Our Ref: EP/70/12/

Alterations & first floor extension, providing a reduced garden room on the ground floor, together with conversion of garage to a gym & 2 new bedrooms, study & bathroom to first floor. Removal of existing pitched roof & replace with lower mono pitched roof

Sandgate House South Strand East Preston Littlehampton

The Planning Committee of this council considered the revised version of this Application at its meeting on 28th August 2012, and following a site visit, at a further meeting on Monday, 3rd September.

1207 SK26
 Sandgate House, East Preston
 Elevations As Proposed - sheet 2
 June 2012
 scale: 1:100

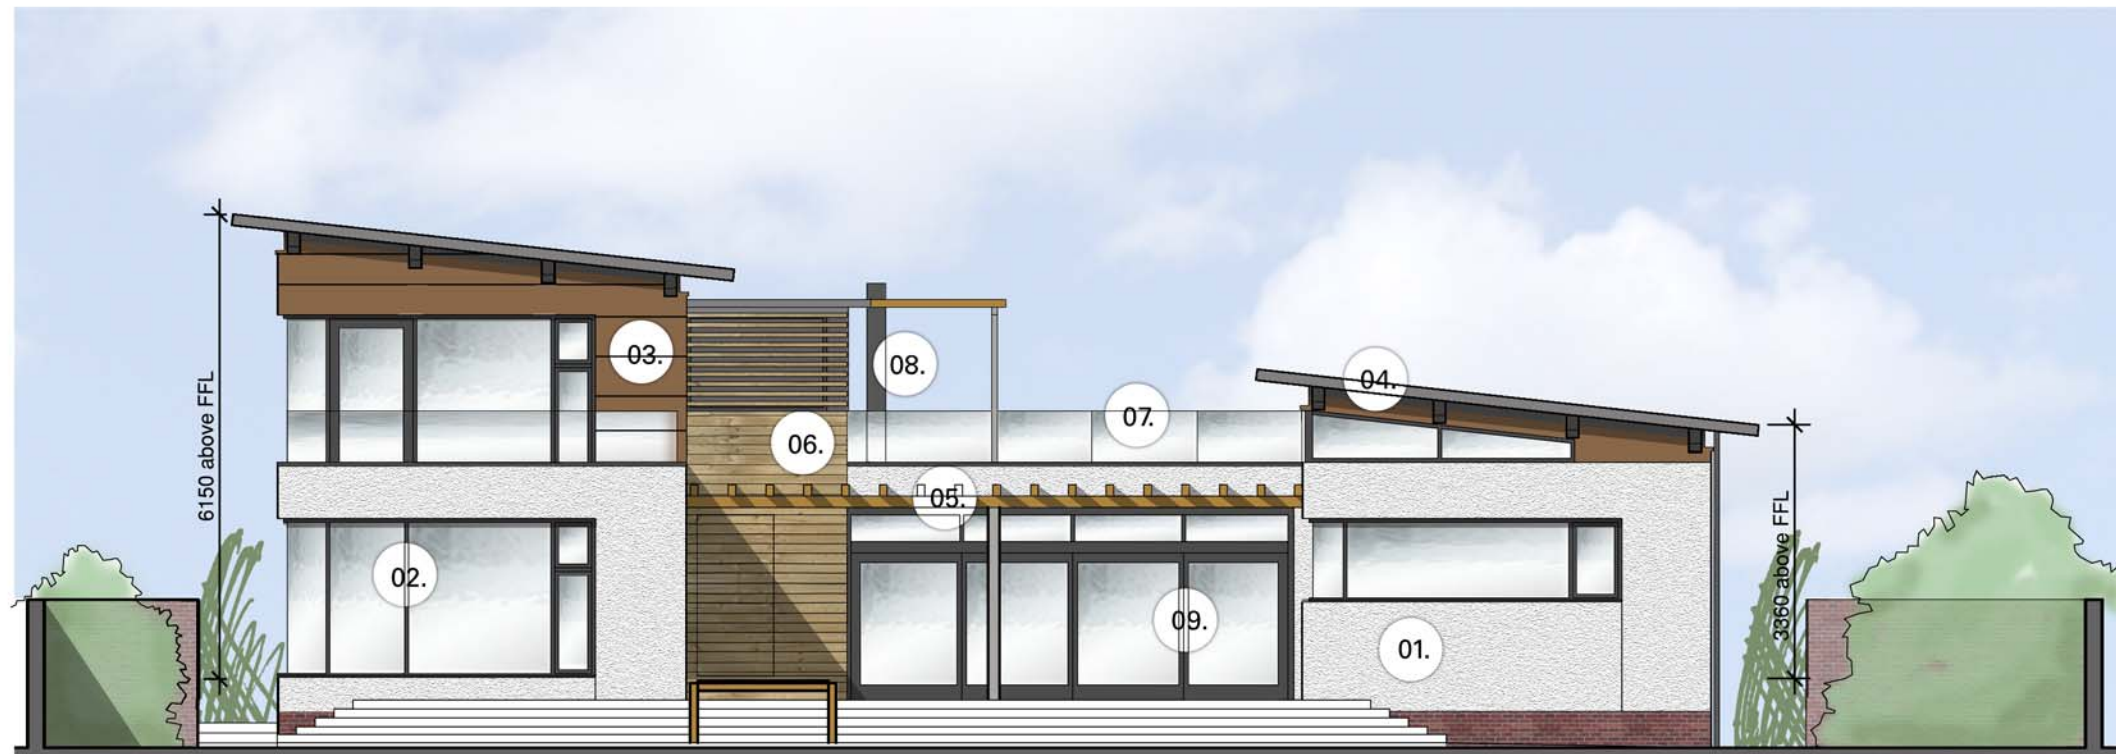
The whole proposal will result in a change of the view from the beach, contrary to the East Preston Village Design Statement, page 10.

Section 3 of Policy DM14 in the emerging Arun Local Plan states that development should ¿Have minimal impact to users and occupiers of nearby property and land.¿ This council is concerned that the proposed balcony may discomfort beach users.

1207 SK25 A
Sandgate House, East Preston
Elevations As Proposed - sheet 1
June 2012
scale: 1:100

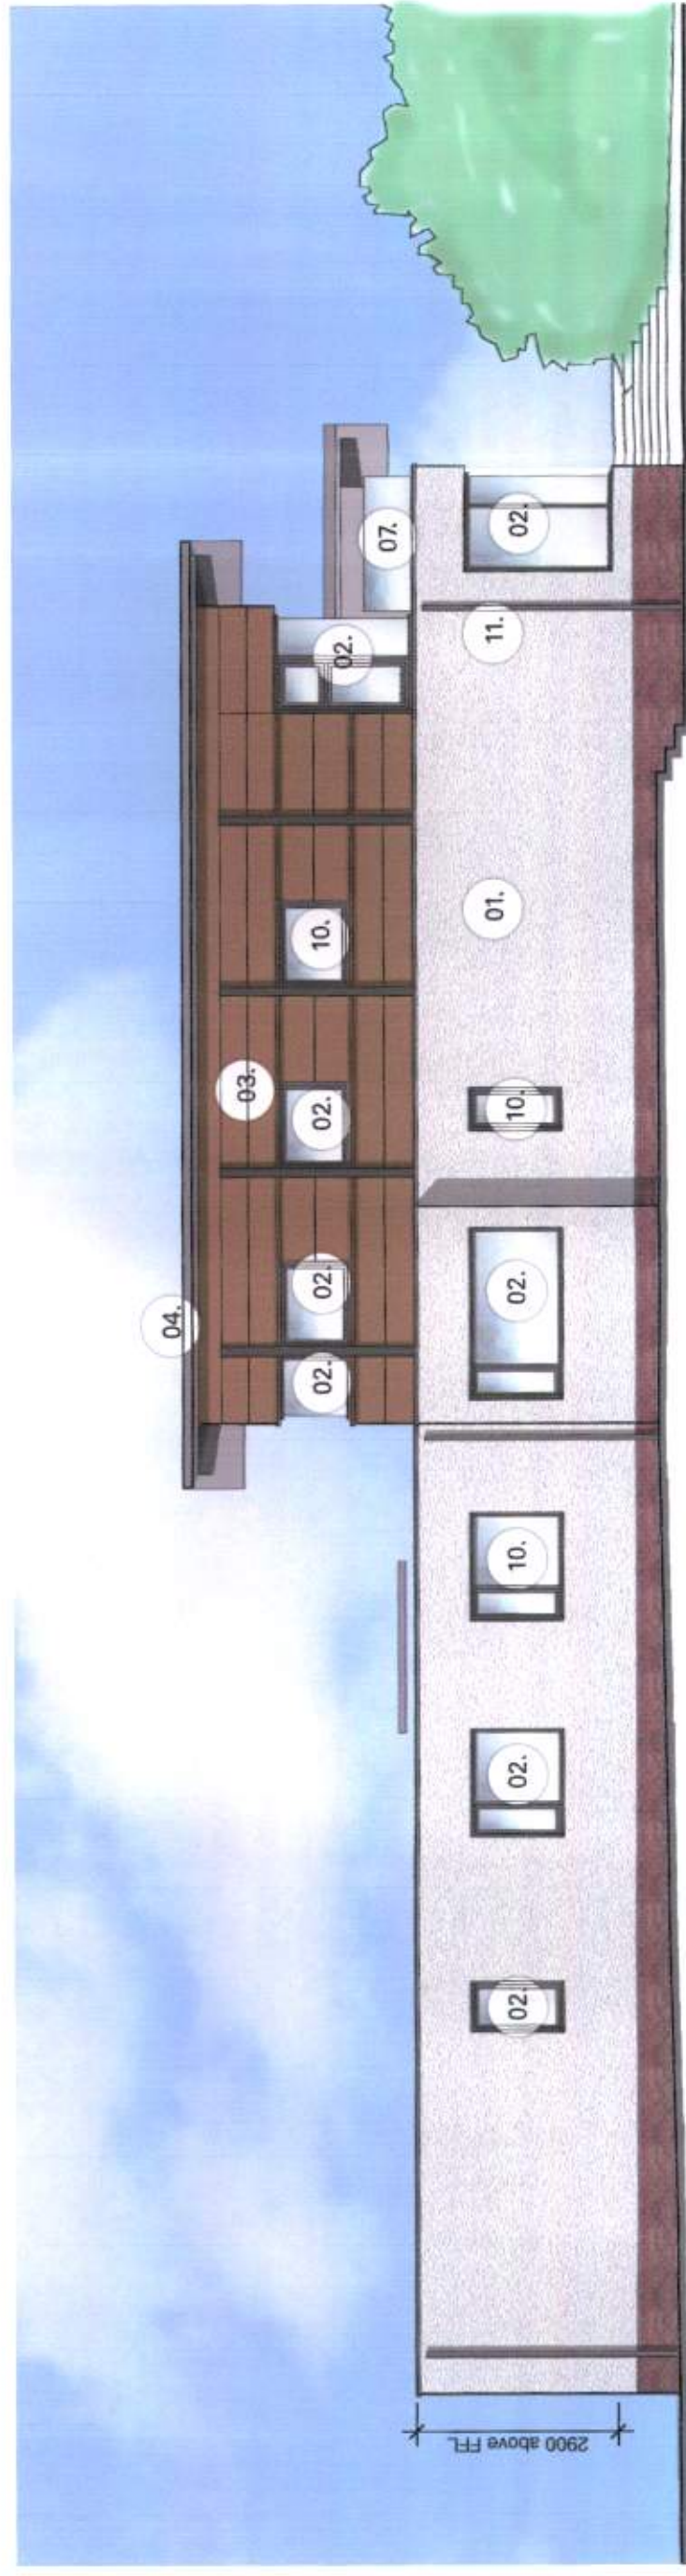
The southern end of the western side of the building will be higher than at present, and this could result in gardens to the east being overlooked. There will be windows in the western elevation and not all of these are shown on plan SK30 as having obscured glazing.

The mass of the upwards extension will result in an overbearing feel for the residents of the properties to the west. It is also expected that the design would erode the views to sea of properties to the north of Sandgate House itself. This council does appreciate that for some of the length of the building the roofline will be lower than at present.
